PROPOSED FIVE ESTUARIES OFFSHORE WIND FARM DEVELOPMENT CONSENT ORDER

PINS REFERENCE EN010115

LONDON GATEWAY PORT LIMITED (IP REF 20049288)

RESPONSE TO APPLICANT'S "10.62 NOTE ON DDCO DRAFTING – APPLICANT’S POSITION ON PROTECTIVE PROVISIONS" SUBMITTED AT DEADLINE 7

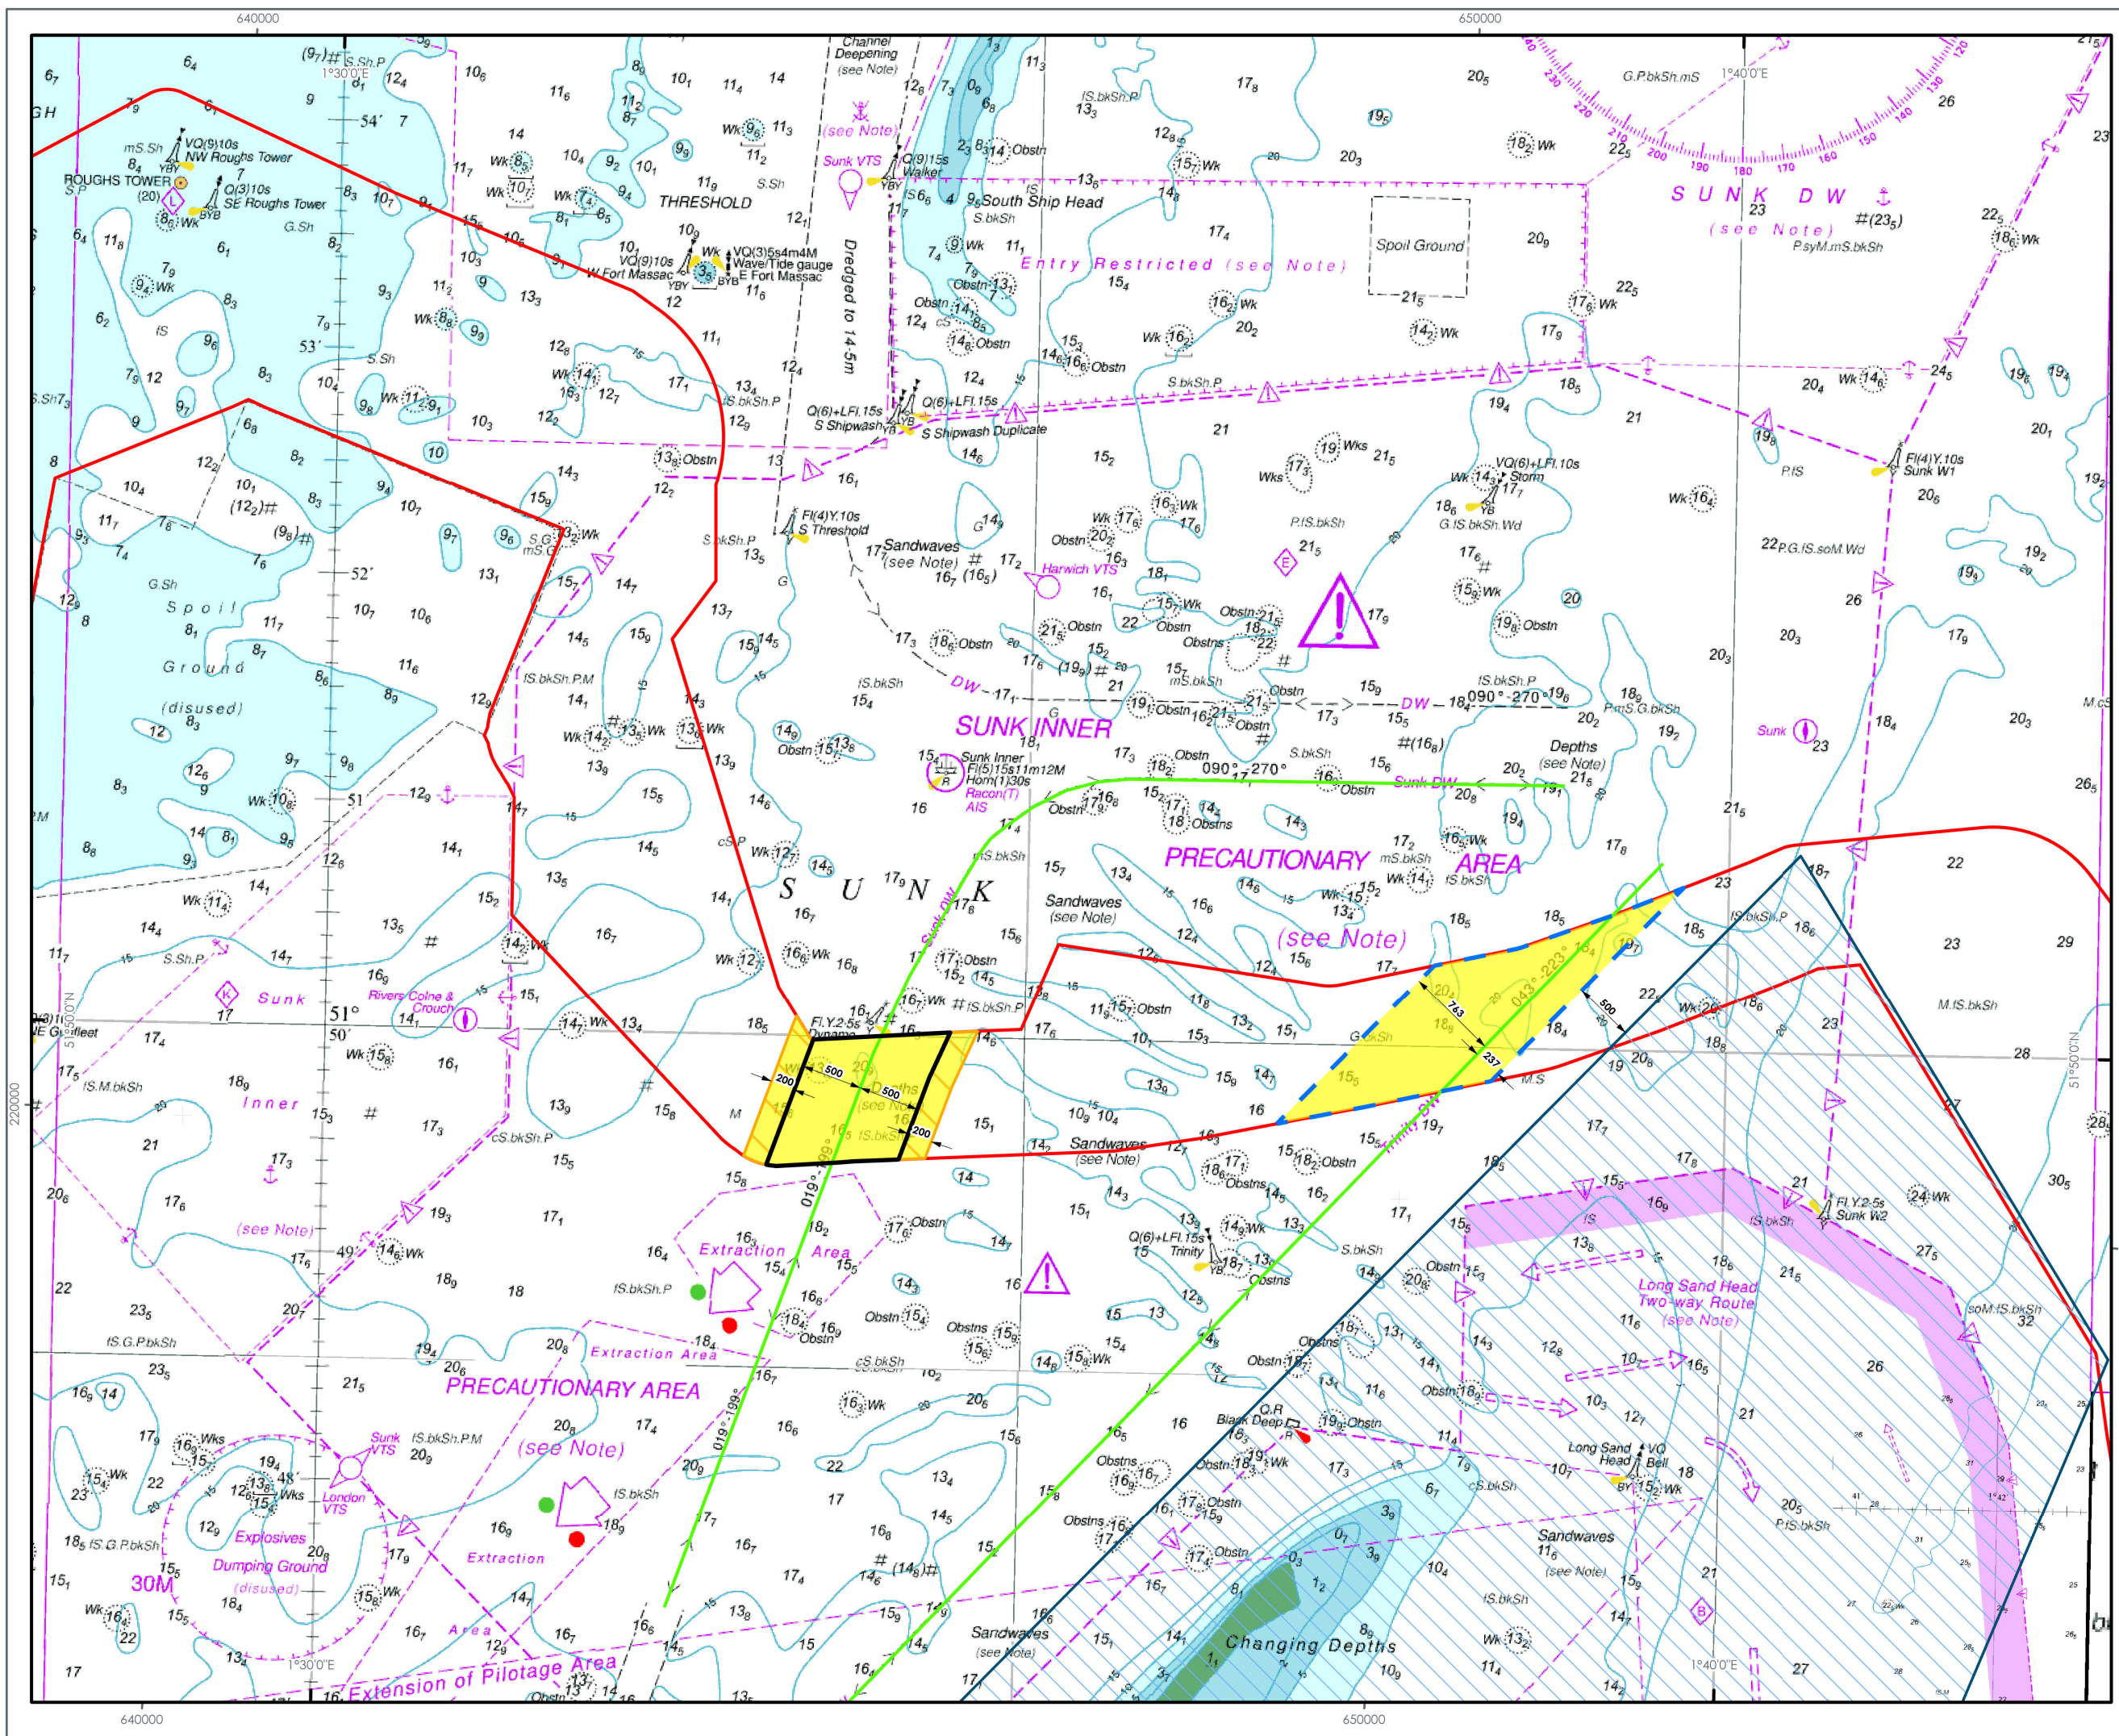
7.6 The Applicant rejects the suggestion made by LGP that the offshore works plans should be amended to try and show the deep water routes. That is not the purpose of the works plans. In addition, the deep water route area are referenced in the DML and in other documents and it makes sense to have one plan showing this restriction in the context of those multiple references than to try and make a plan which has another purpose add this detail.	<p>The DWRs need to be shown on a plan that is a certified document. Given that the boundaries of the DWRs to be specified are delineated in part by the boundary of the works powers under the Order, we had suggested amending the Offshore Works Plans – this was purely for efficiency and to avoid creating a new plan to be certified.</p> <p>However, LGPL has no objection to the areas instead being shown on a new plan, being the Deep Water Route Cable Installation Area (Future Dredging depths) plan that REP7-008 now refers to.</p>
